Aighton Bailey and Chaigley Parish Council
c/o 17 Smithy Row
Hurst Green
Clitheroe
BB7 9QA
Email: clerk@aightonbaileyandchaigley-pc.gov.uk
07921472172

Planning Application No: 3/2026/0587 Grid Ref: 367732 441971 Proposal: Construction of an earth banked slurry lagoon and associated landscaping to include native species tree planting Location: Plane Tree Farm Chipping Road Chaigley BB7 3LT

Proposed Site Plan  
1:500 @ A3

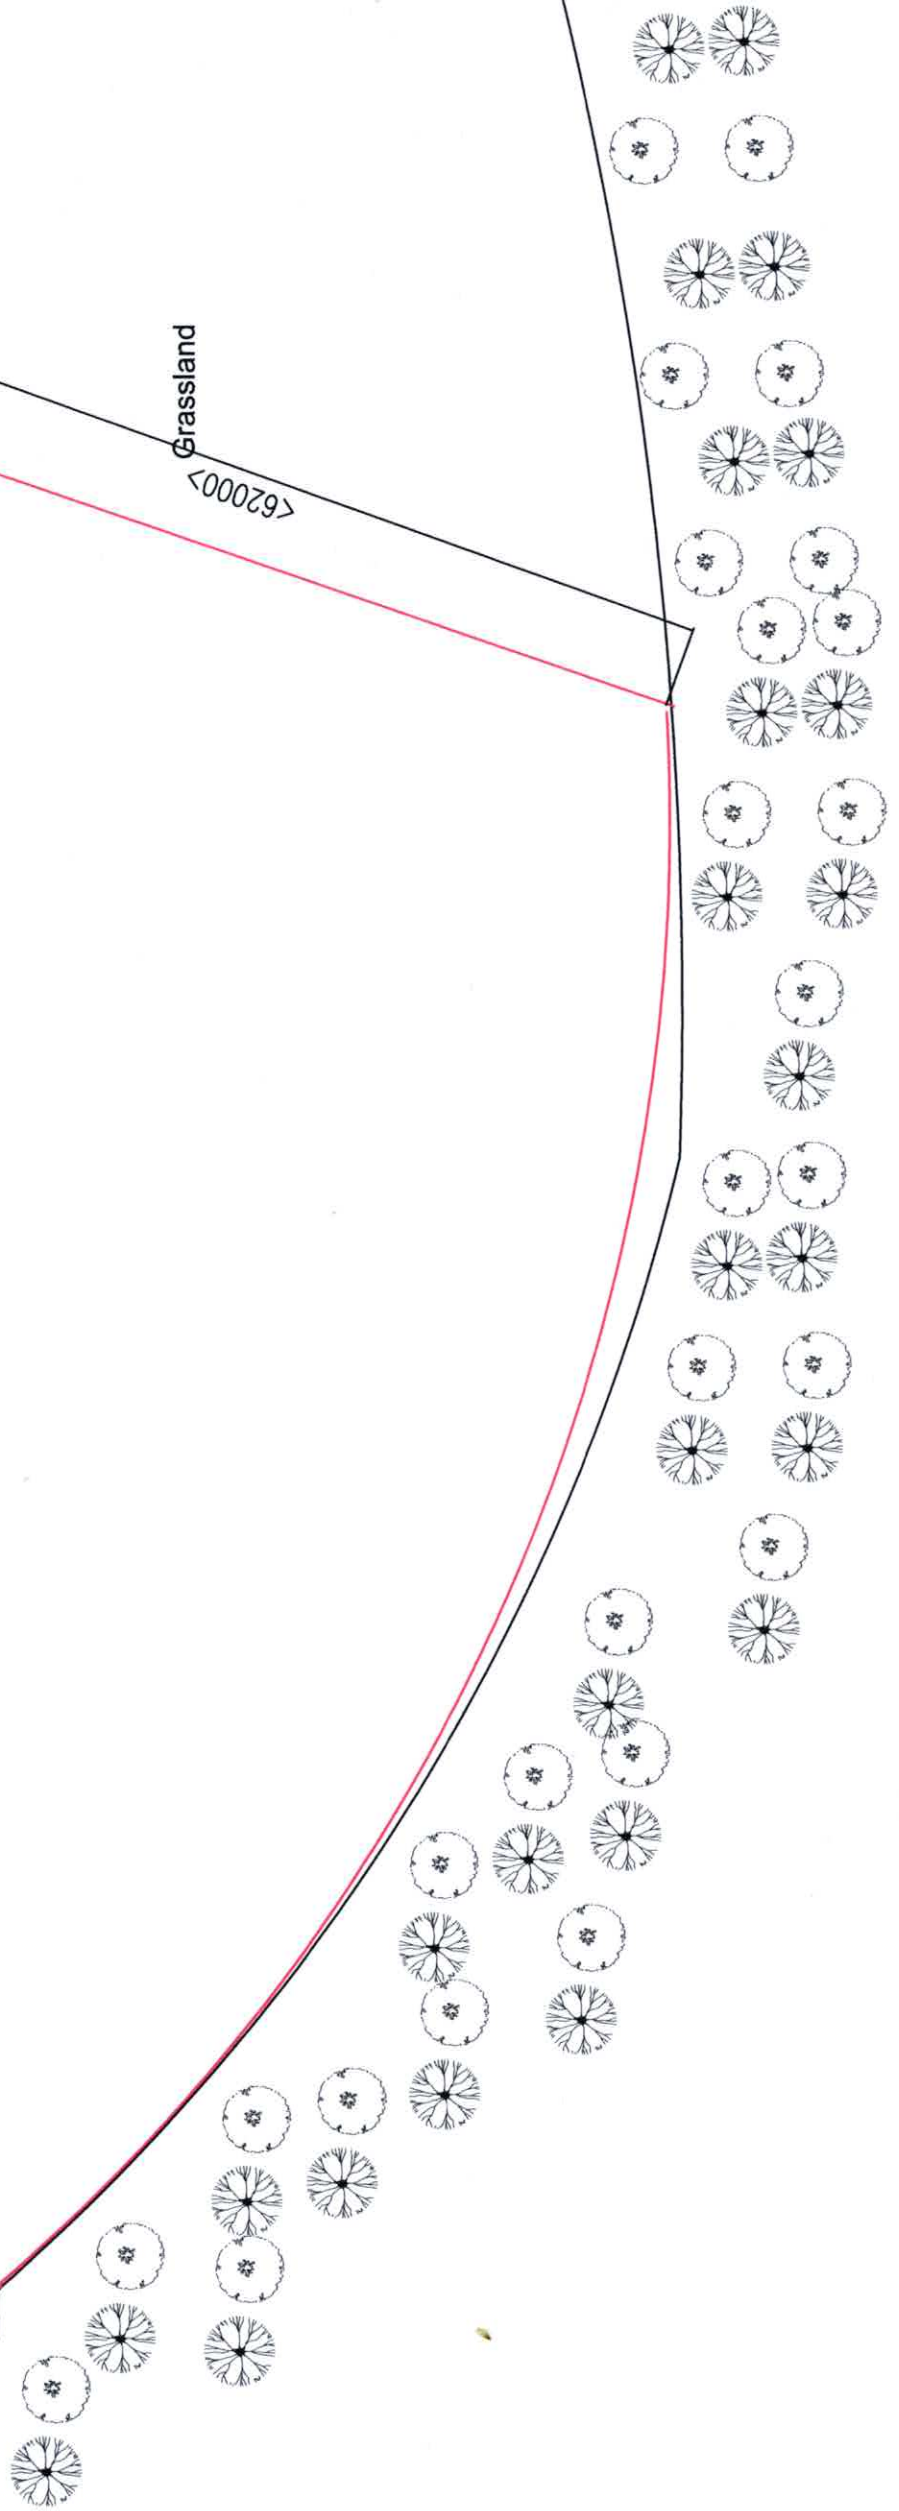
The concerns of the residents include the physical siting of the proposed new slurry lagoon closer to properties in the area than the current unit. This new proposal is for a much larger lagoon than currently in use by the farm. There is also the question of any impact on the area which is within the boundaries of The Forest of Bowland Natural Landscapes (formerly an AONB) and as such this development may be seen as detrimental to the natural topography. The new site is also nearer to a watercourse which can become very full during periods of heavy rain.

The Parish Council have taken all the above points into consideration and would request that the Planning Department consider whether it is possible for the applicant to consider using a different site within the farm boundaries.
